## **Phase 3 – Catalyst, Bicester** **Technical Note – LLFA / CDC Drainage Response**

This technical note has been produced as an addendum to Application No: 22/03693/DISC relating to discharge of Condition 18 (SW Drainage). "Phase 3" (Units 10-13) is to be completed in one single sub-phase, completing the 3<sup>rd</sup> and final phase of development at the wider Catalyst development. Please find below Bailey Johnson Hayes responses to consultee comments received to date.

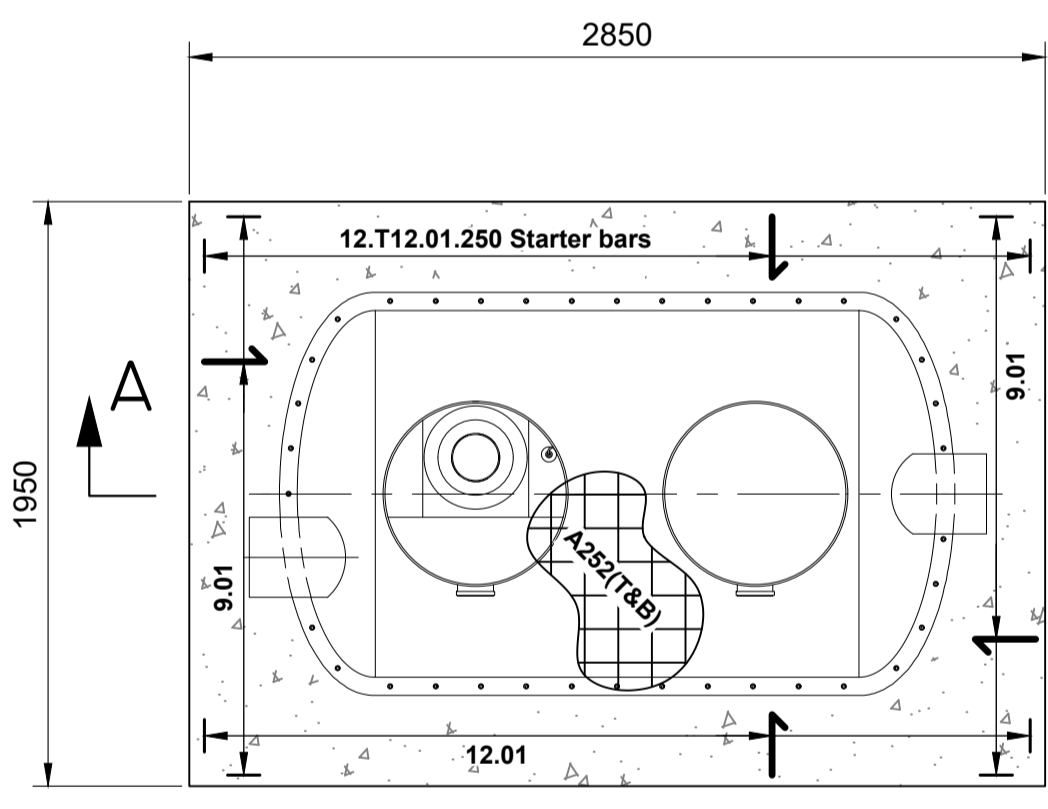
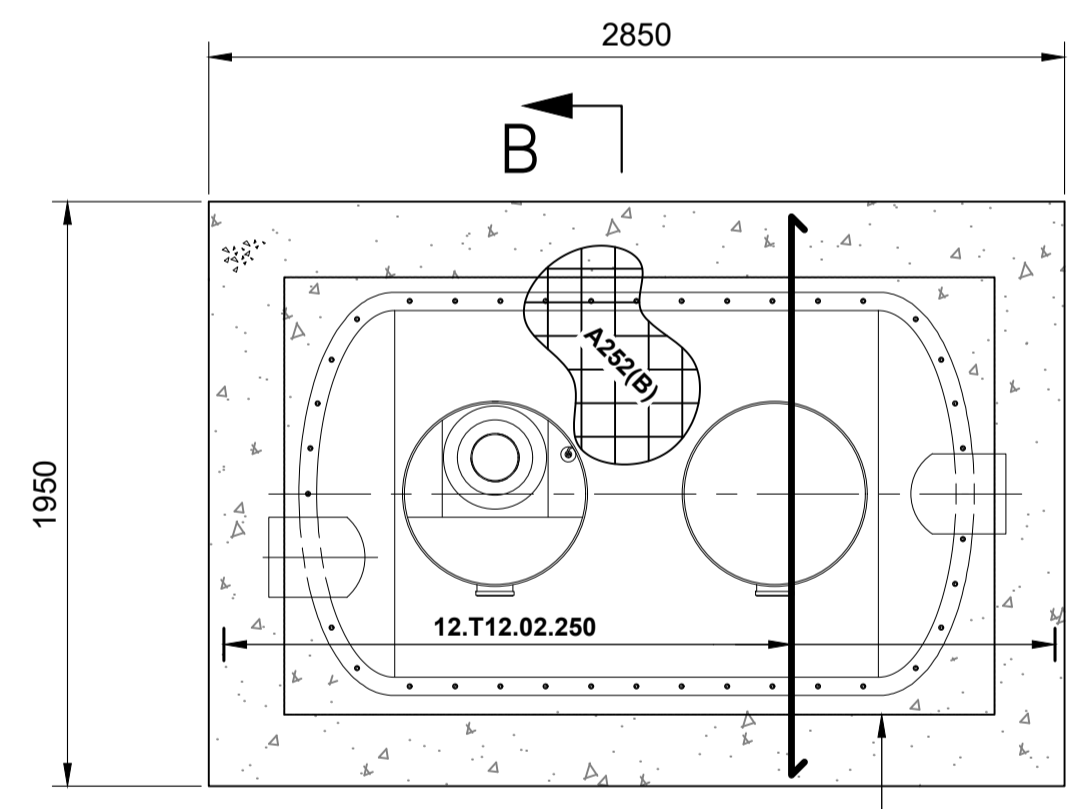
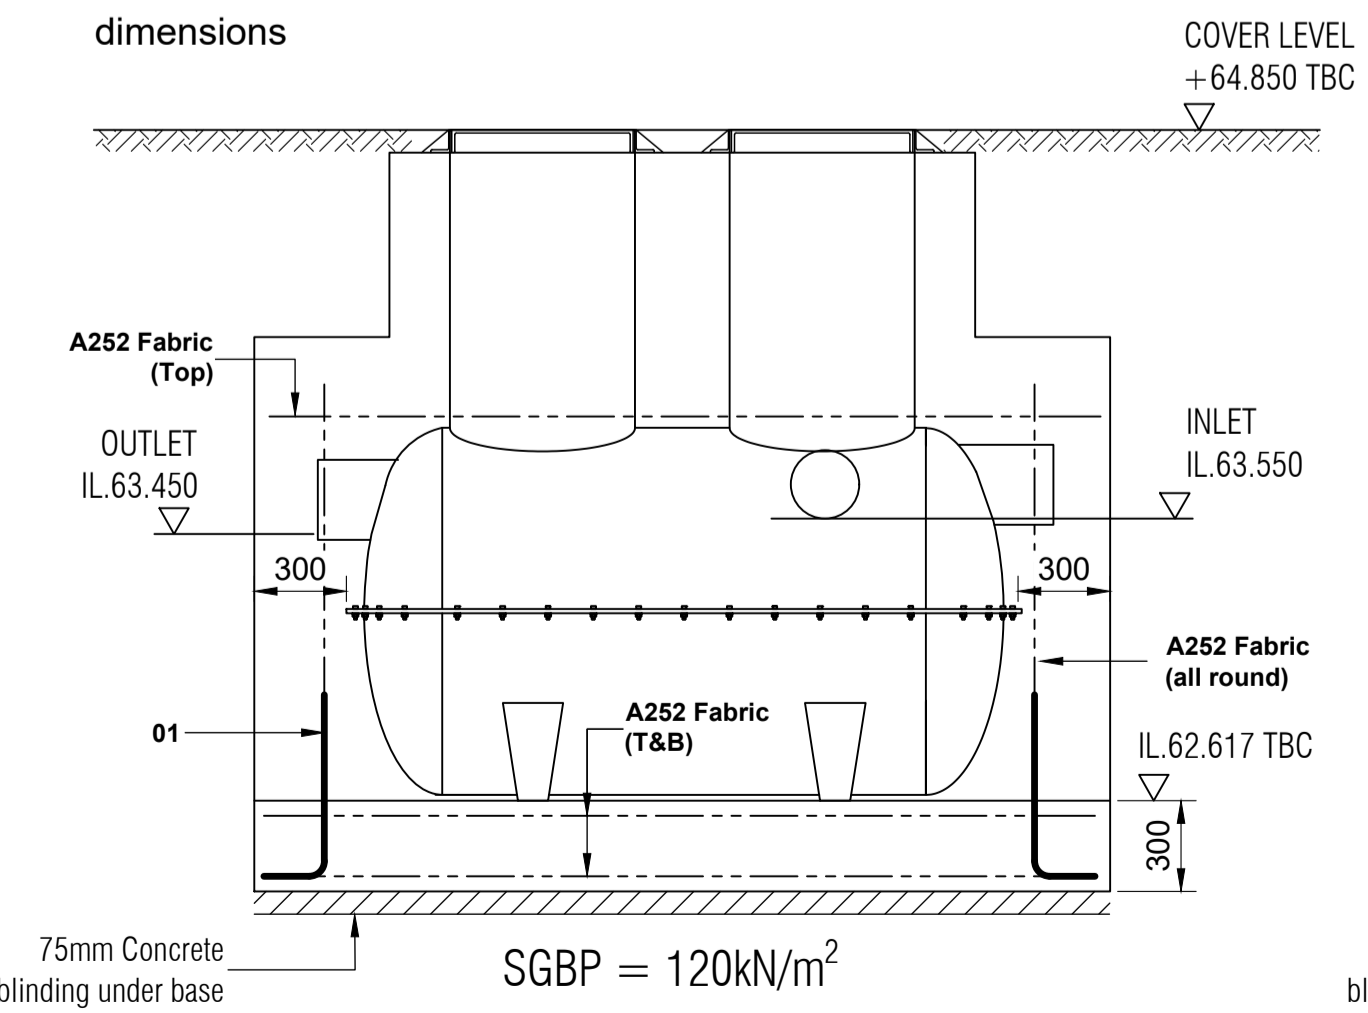
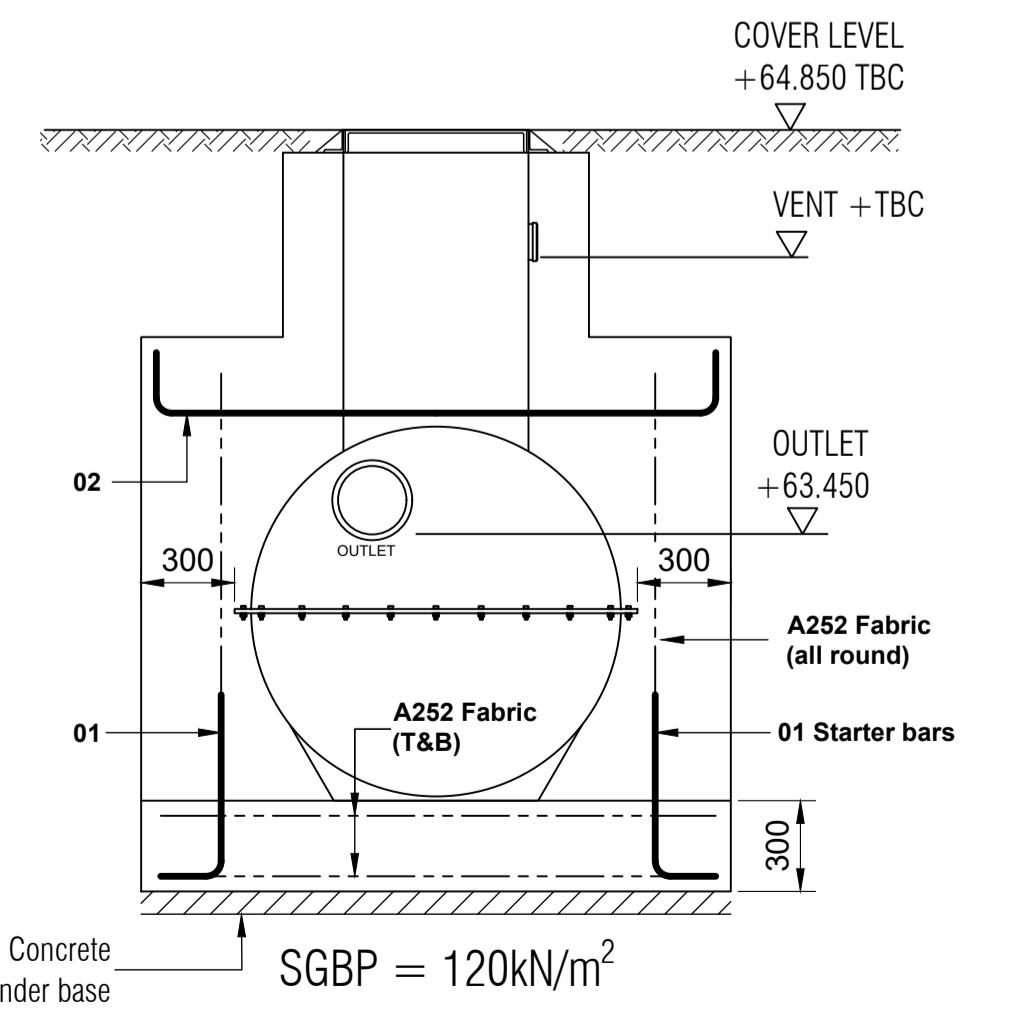
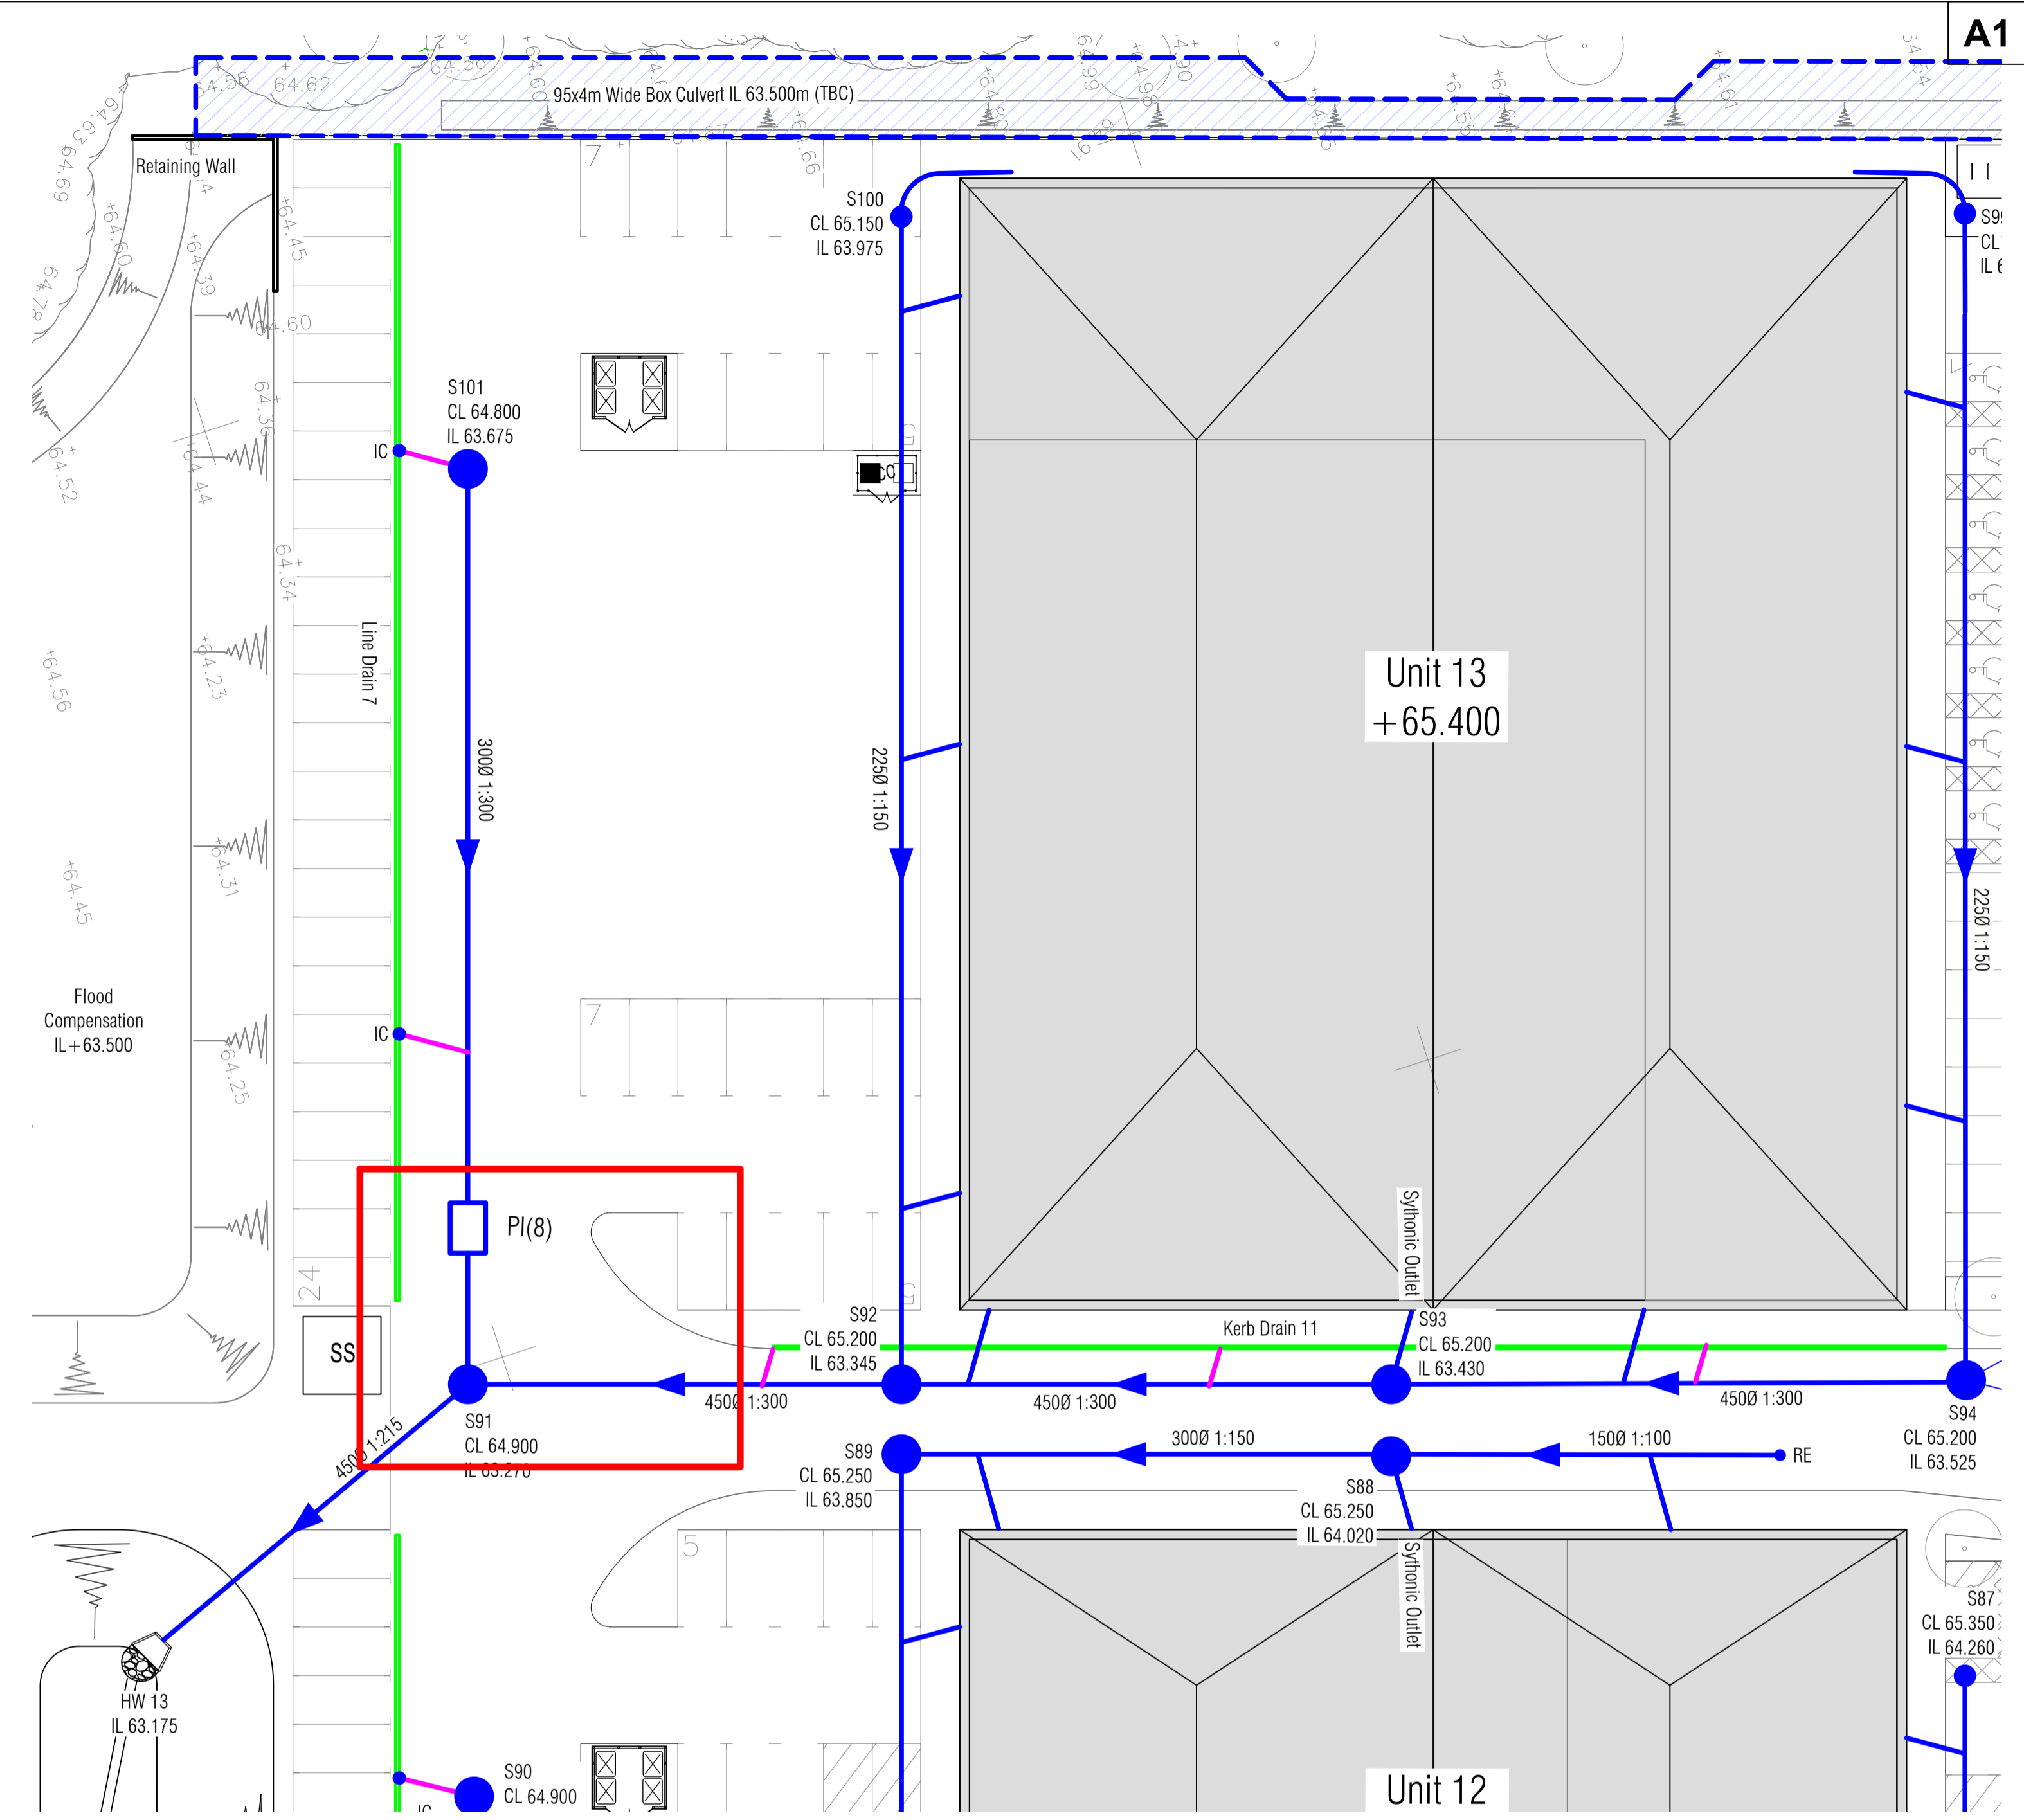
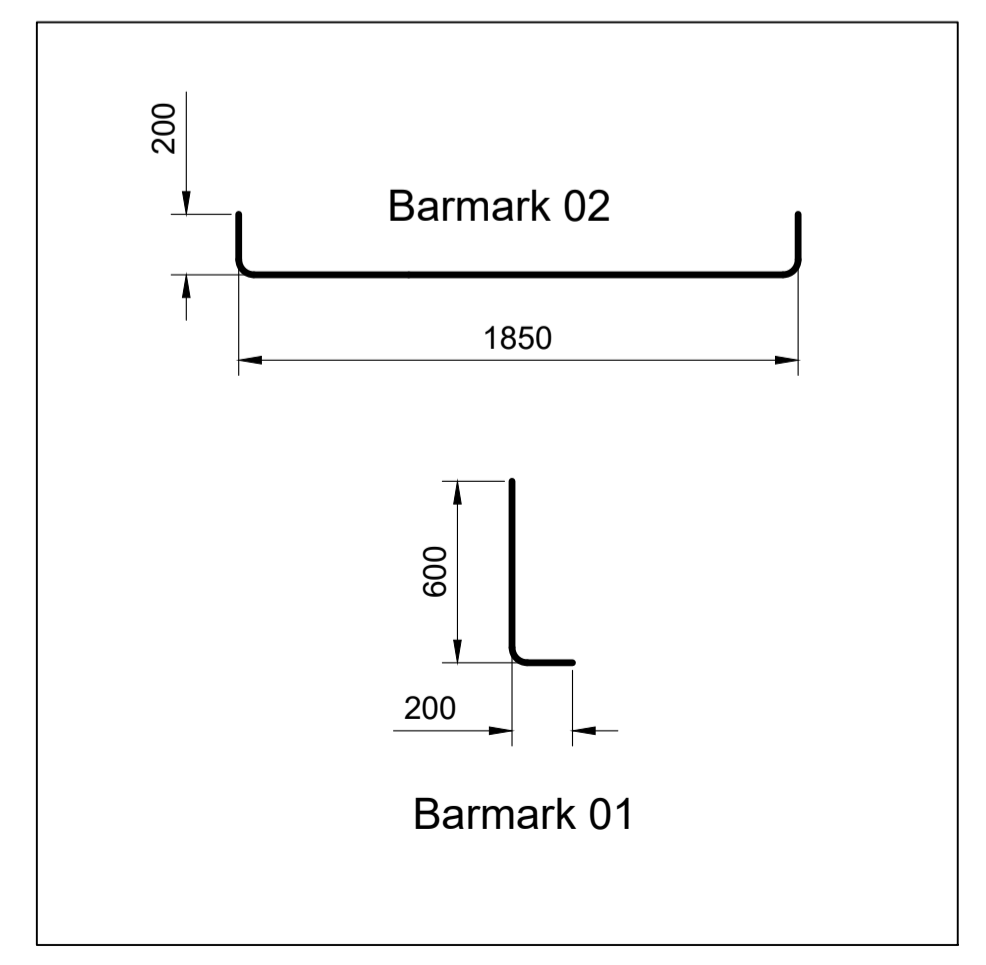
2. Provide SuDS construction details drawings.

New Drawings No. S1358-PH3-14, 15, 16, 17, 18 & 19 are now submitted to provide full details of the Attenuation Basin 1, Petrol Interceptors 6-8, Permeable Paving, Hydro-brake outlet details and flood compensation control details.
